Ref: D16/41342, F12/72-05, LA33547
RJ:EF

1 December 2016

MODIFICATION (2) OF PROJECT APPROVAL MP 08_0167 FOR A RESIDENTIAL SUBDIVISION, BELLE O'CONNOR STREET, SOUTH WEST ROCKS

Title:  
**GENERAL ARRANGEMENT  
& LOT LAYOUT PLAN**

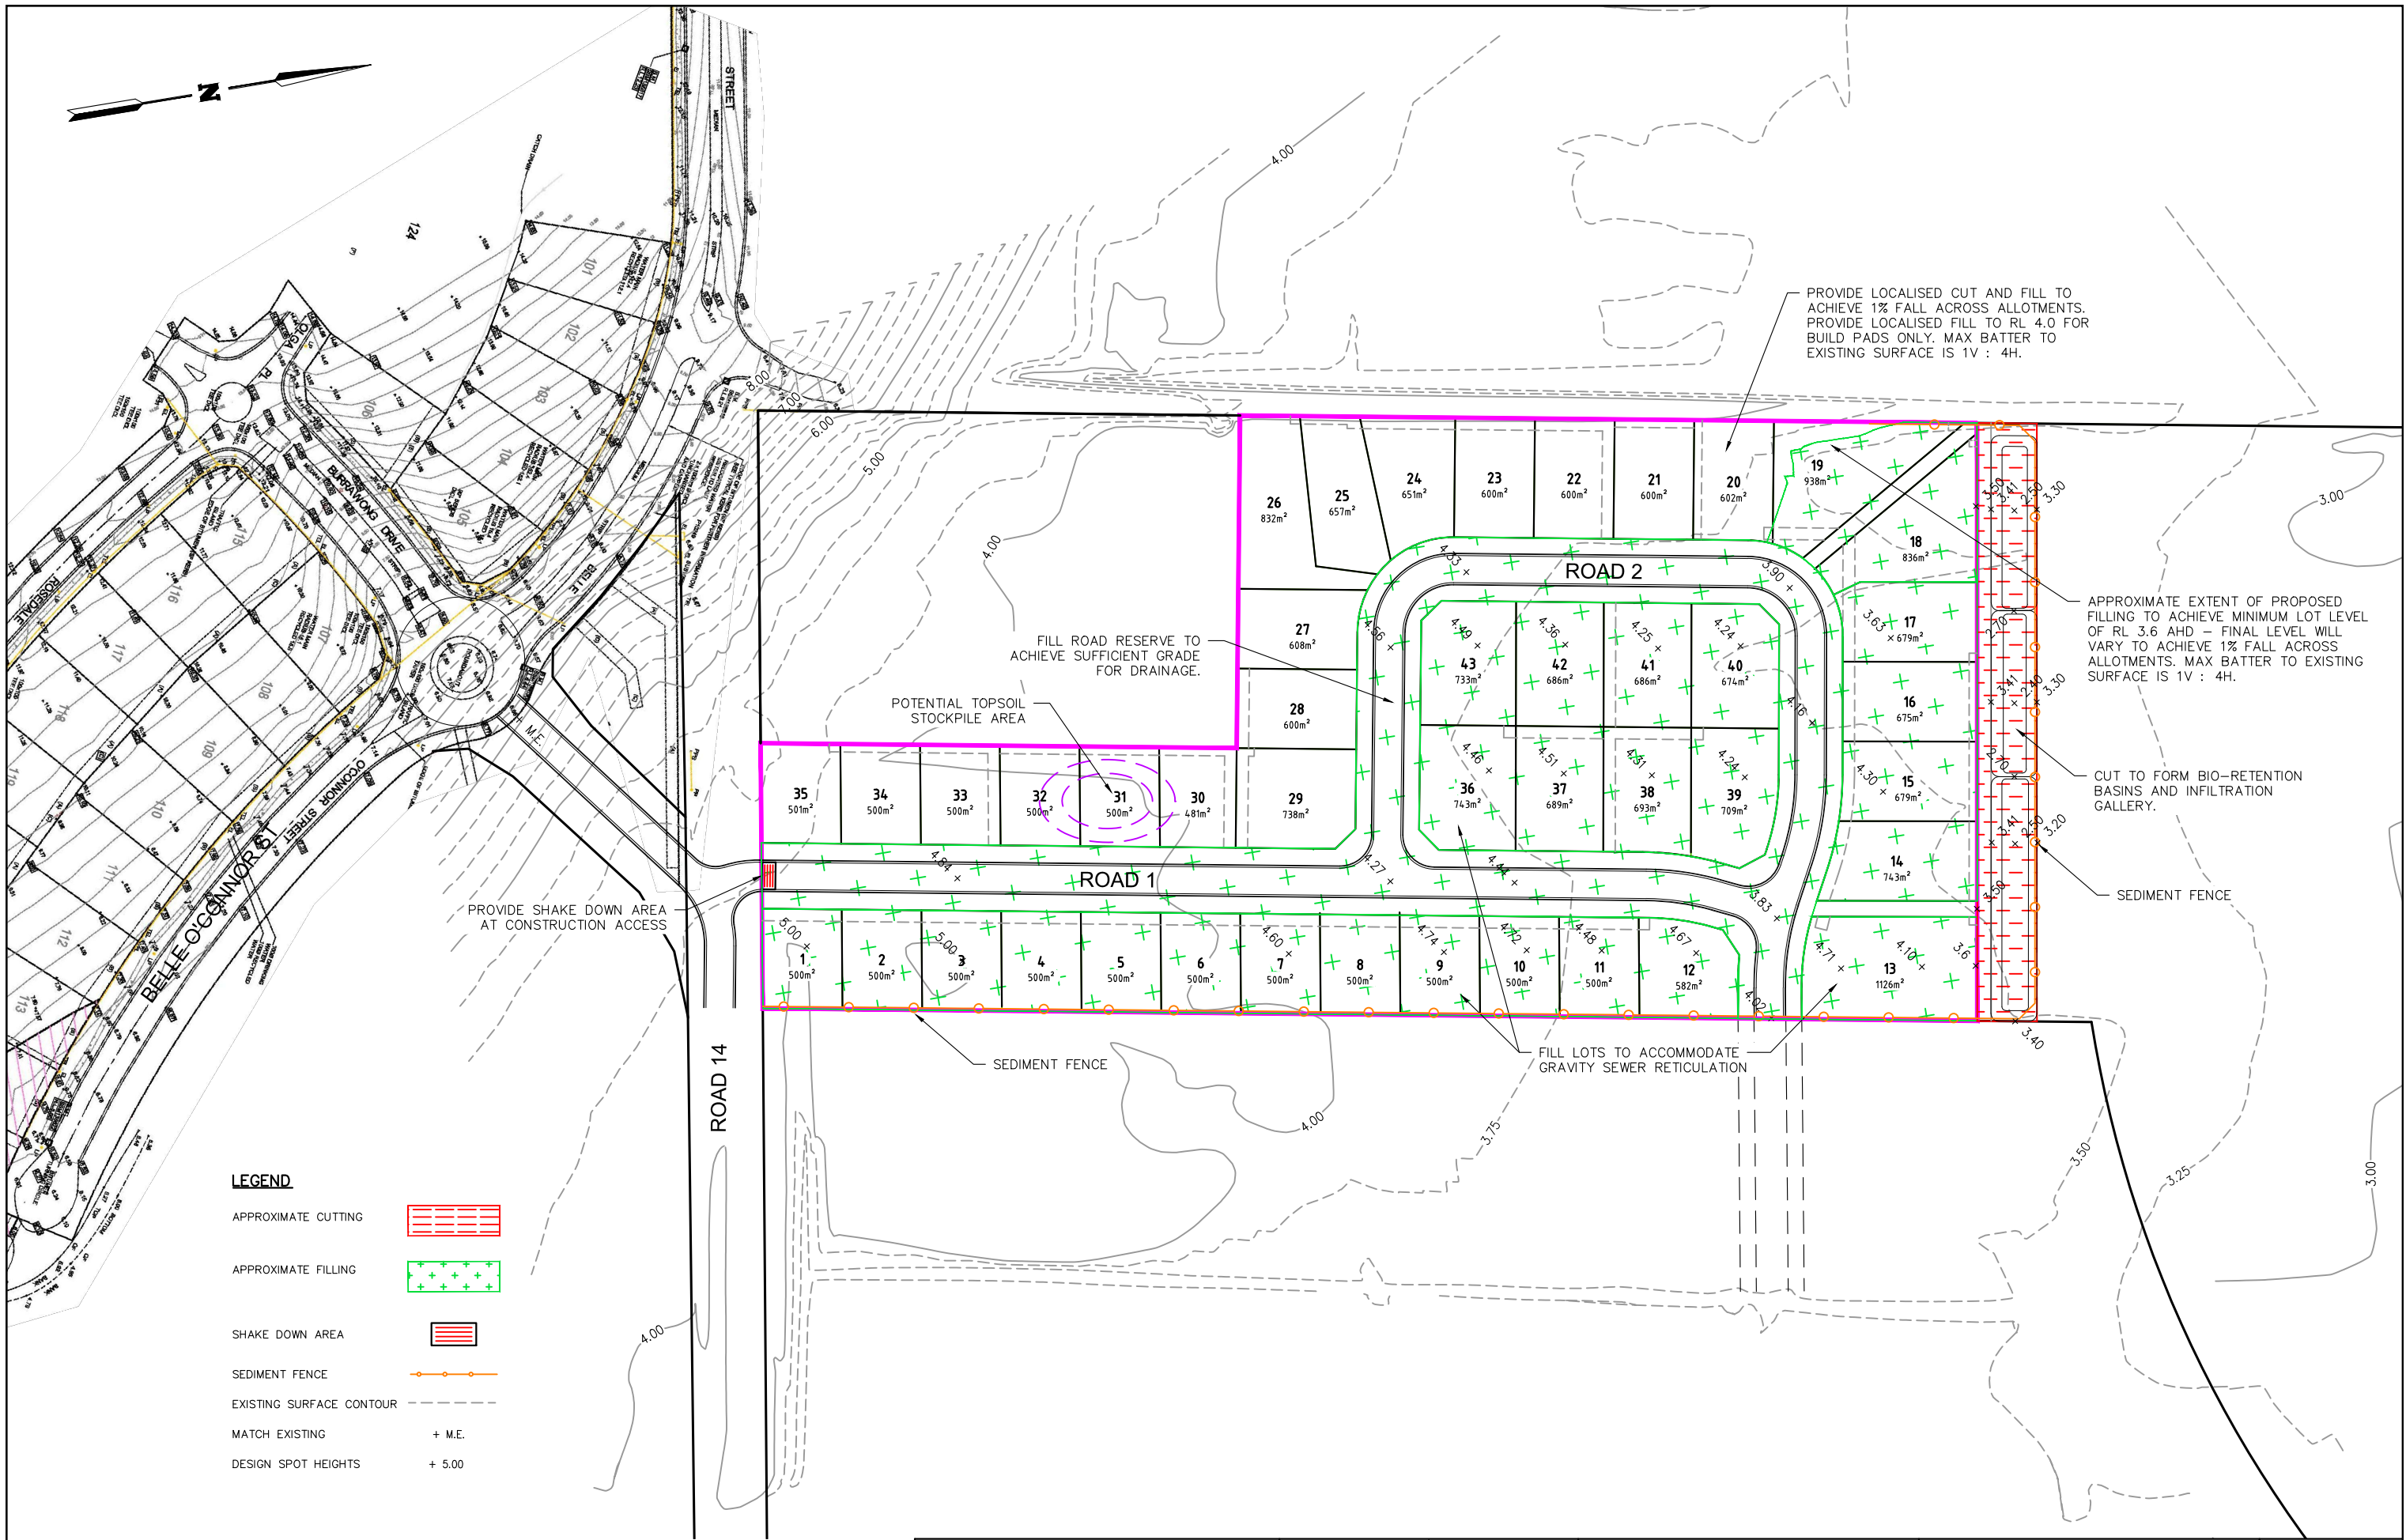
- Vehicular access - The documentation does not demonstrate how vehicular access to Lot 36 will be provided if it is to be developed independently of Stages 1-9 of the

project. It would seem that the development of Lot 36 will be reliant upon Stage 1A being completed first, in particular the extension of Burrawong Drive from the Belle O'Connor roundabout. Alternatively, a portion of the extension of Burrawong Drive could be constructed in accordance with the project approval as part of the development of Lot 36.

- New intersection - An assessment of the traffic impacts associated with the new road connection to Burrawong Drive has not been provided nor is it consistent with the construction certificate plans for Stage 1A of the project that are currently being assessed by Council. For example, the location of the new road connection will impact upon (as depicted in the current plans for the Stage 1A construction certificate) utility services and the proposed culvert crossing the Burrawong Drive extension.

- Internal road layout - The approved internal road layout avoided cul-de-sacs and dead ends were provided only where connections to future development were proposed. Modification (2) proposes to remove two of the road linkages between Stages 9 and 10 resulting in dead ends for two of the roads in Stage 9. The documentation submitted does not address the impacts of this, in particular whether cul-de-sacs will be provided at these points and any associated reduction in lot size for adjoining lots.

STORMWATER MANAGEMENT

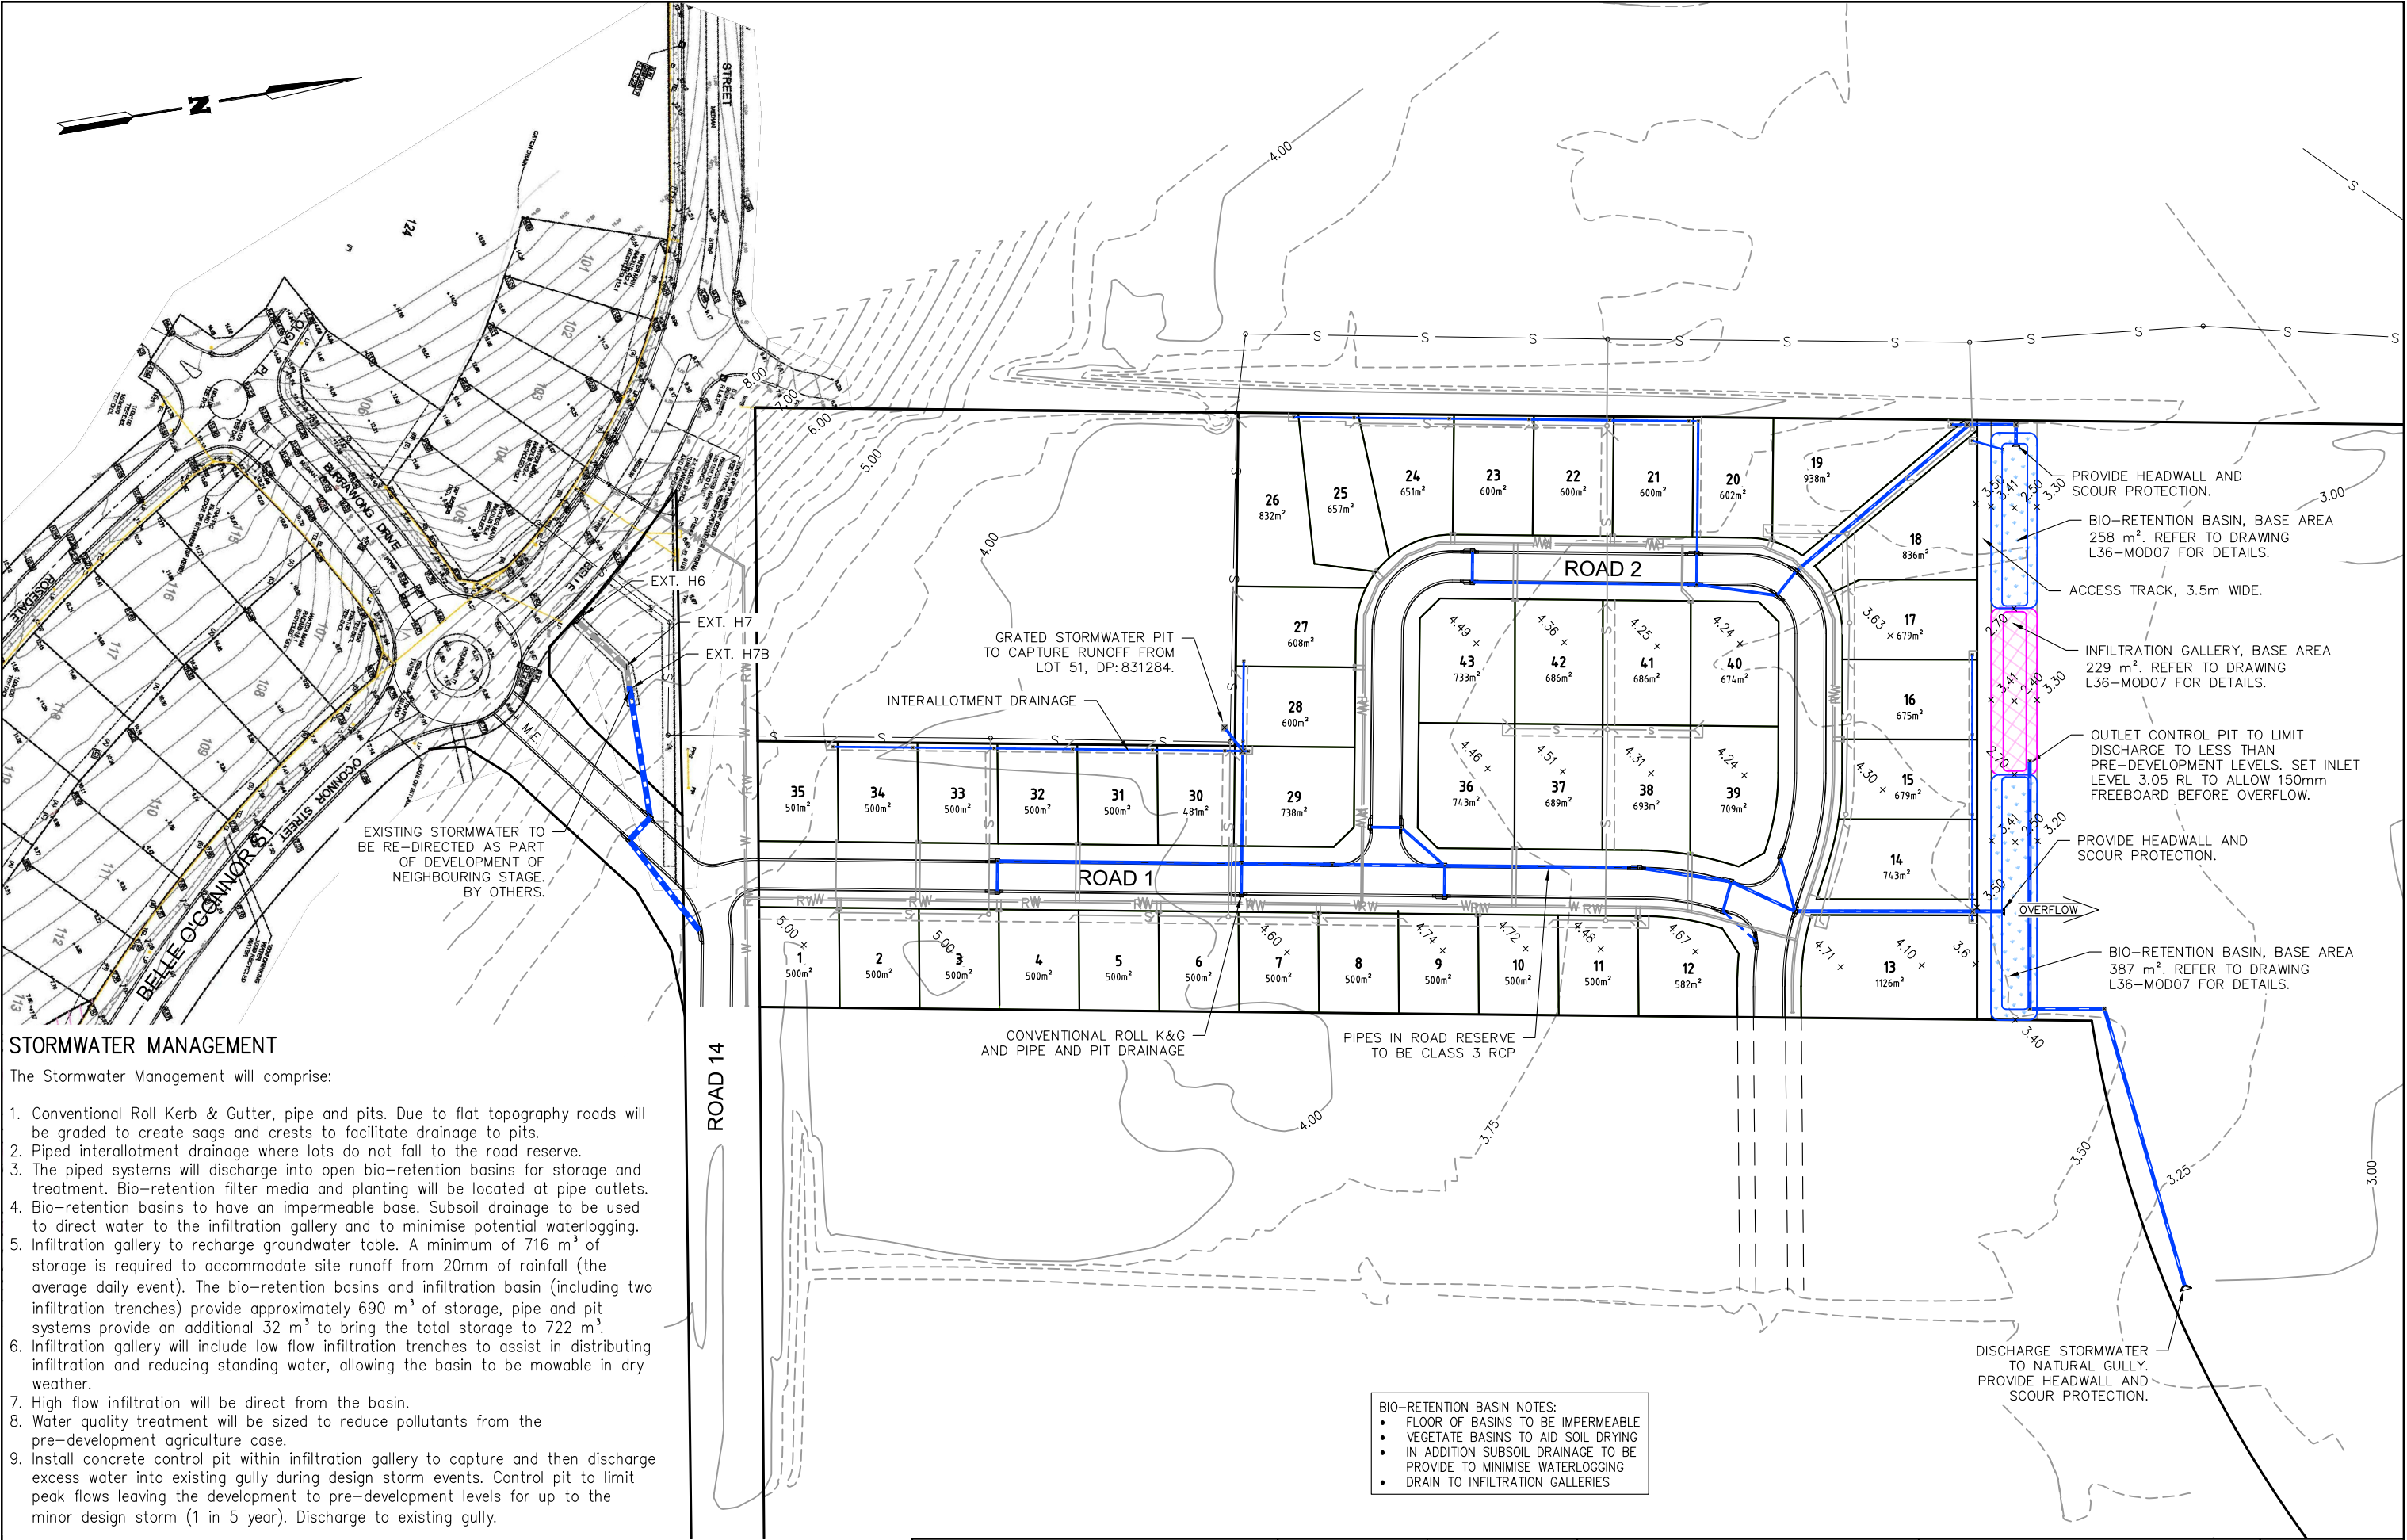
- The development proposes an additional 14 lots which, whilst only a small increase relative to the total subdivision size, should be considered in the overall water quality and stormwater strategy to ensure adequate water quality is maintained and infrastructure meets the requirements of the subdivision.

- The documentation does not discuss how stormwater is proposed to be managed if Lot 36 is to be developed independent of, and any consequential impacts on, the remainder of the project.

- The development of Lot 36 seems to rely upon stormwater treatments which form part of Stages 1-9 of the development. As these stages are under different ownership, Council has concerns regarding not only the timing of the development of the adjacent stages, but also the ability for adequate stormwater treatment for Stages 10 and 11. If Lot 36 is to be developed independently, the stormwater strategy for this lot should demonstrate that water quality equal to or better than the pre-development water quality discharging from the site can be achieved, consistent with condition B13 of the project approval.
